Brain Knox
The Widewaters Group
145 Kingspine Boulevard
Portland, Maine 04102
CBL: 029AA016

11/13/2000

Chief Electrical Inspector
City of Portland
Cc: Central file
Mike Nugent
Sam Hoffses

1 TYPICAL KING GUESTROOM PLAN - ELECTRICAL
E3.01 1/4"=1'-0"

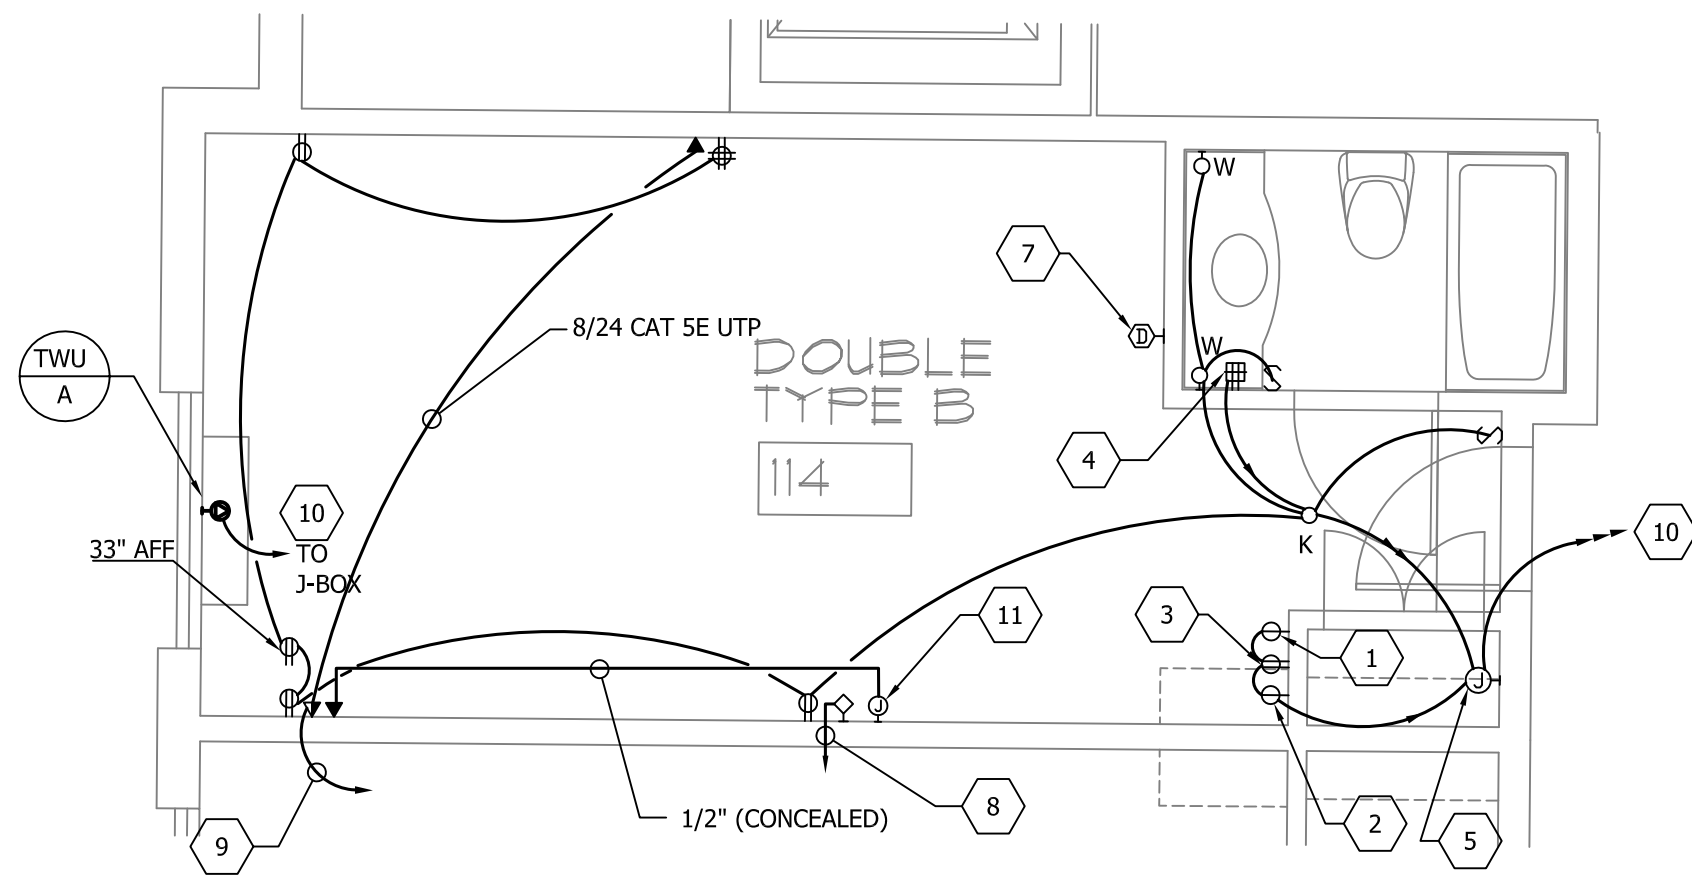
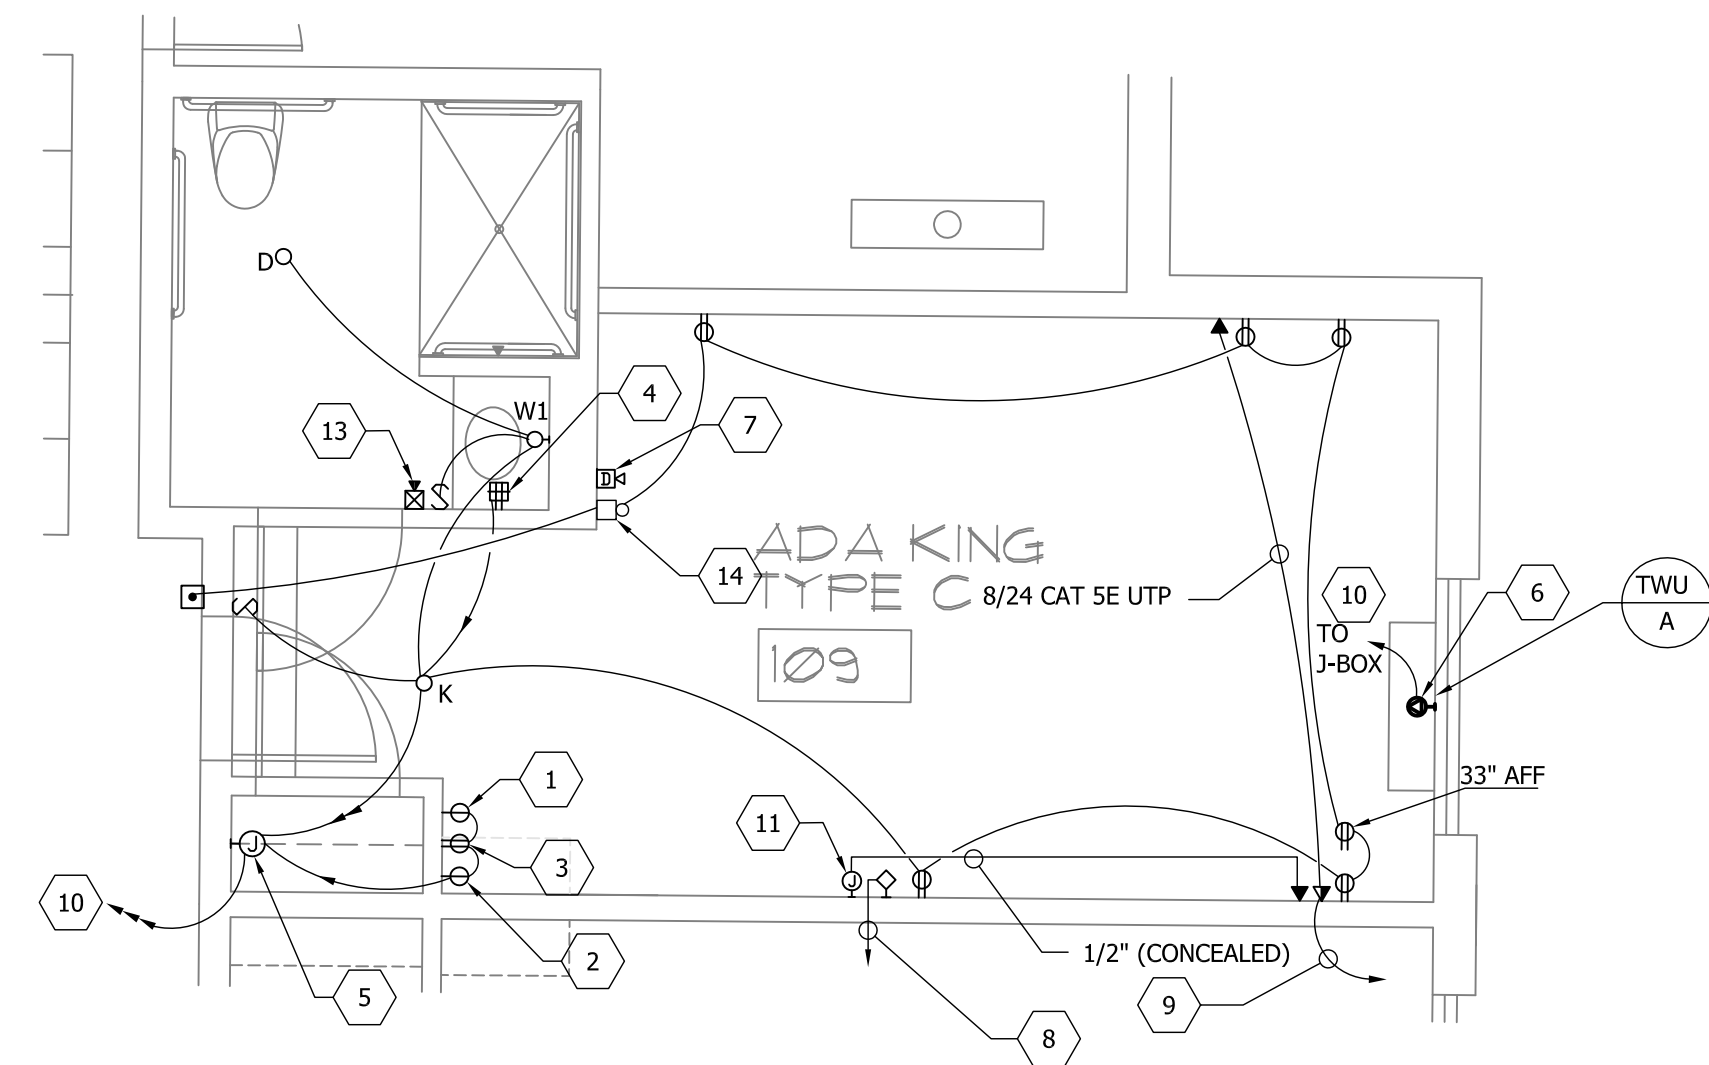
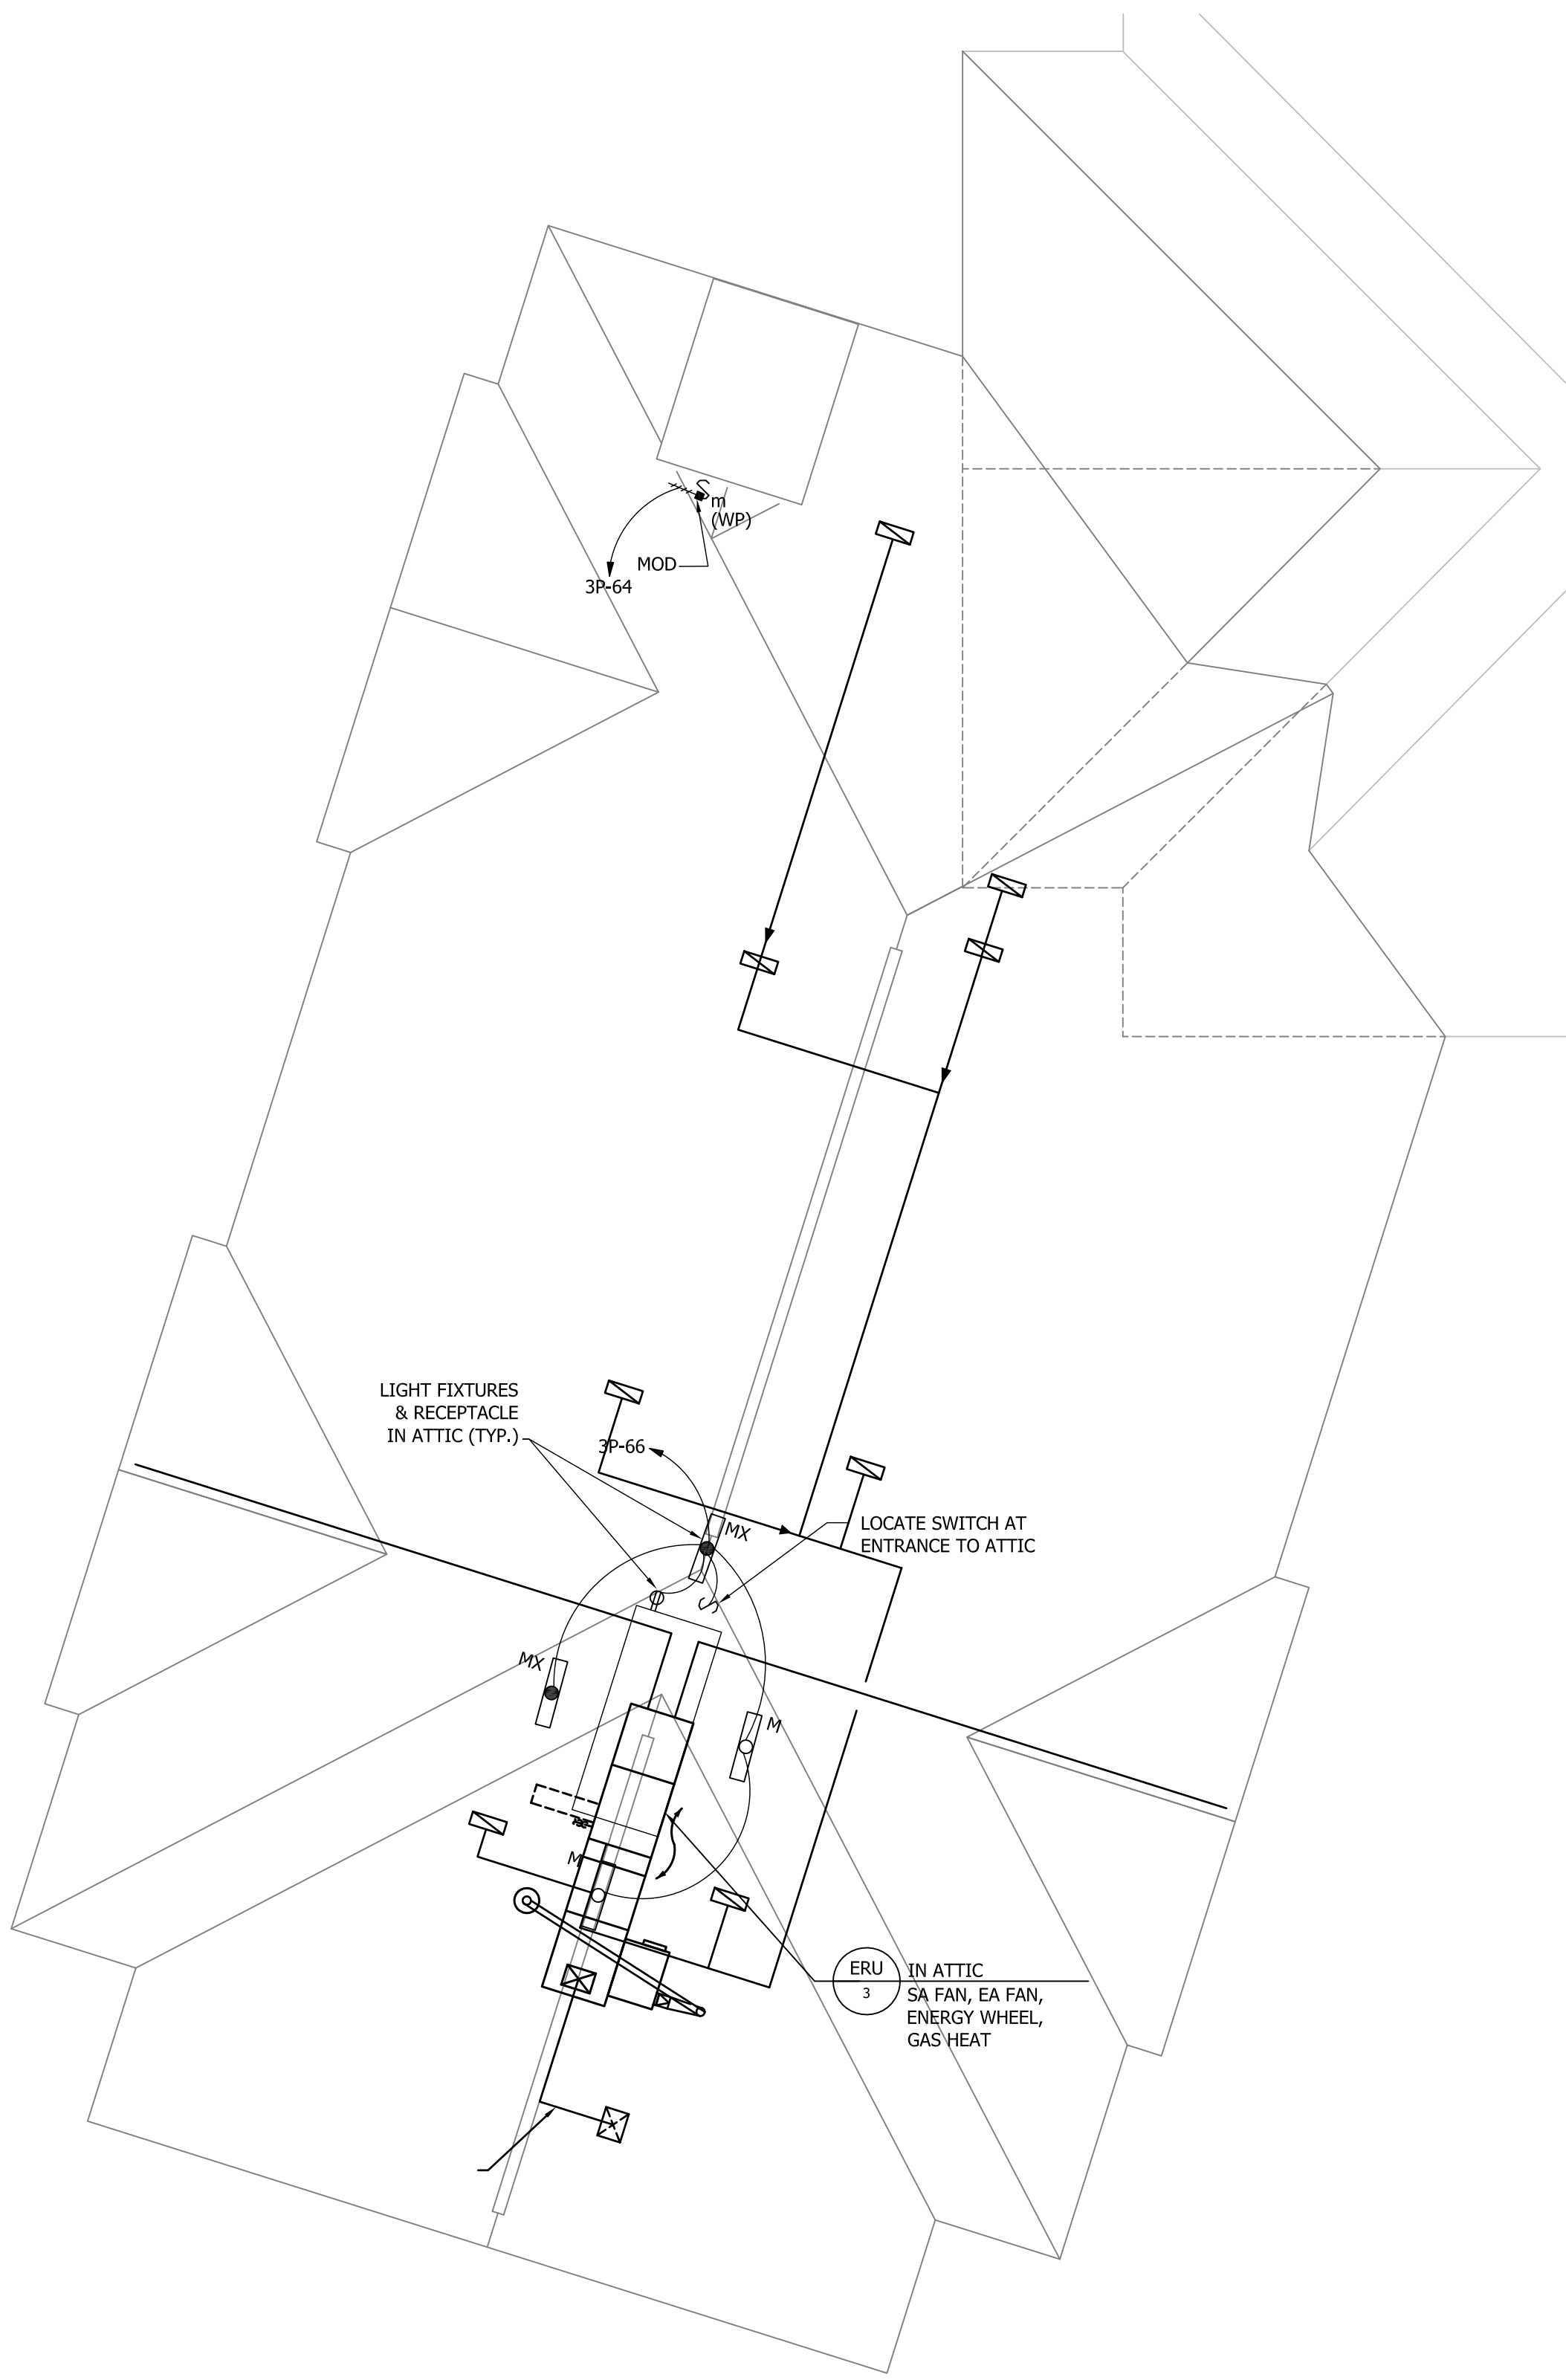
All guest rooms shall have at least two receptacle outlets readily accessible to any occupants of each guest room pursuant to NEC 1999, ART: 210-60(a) & (b).
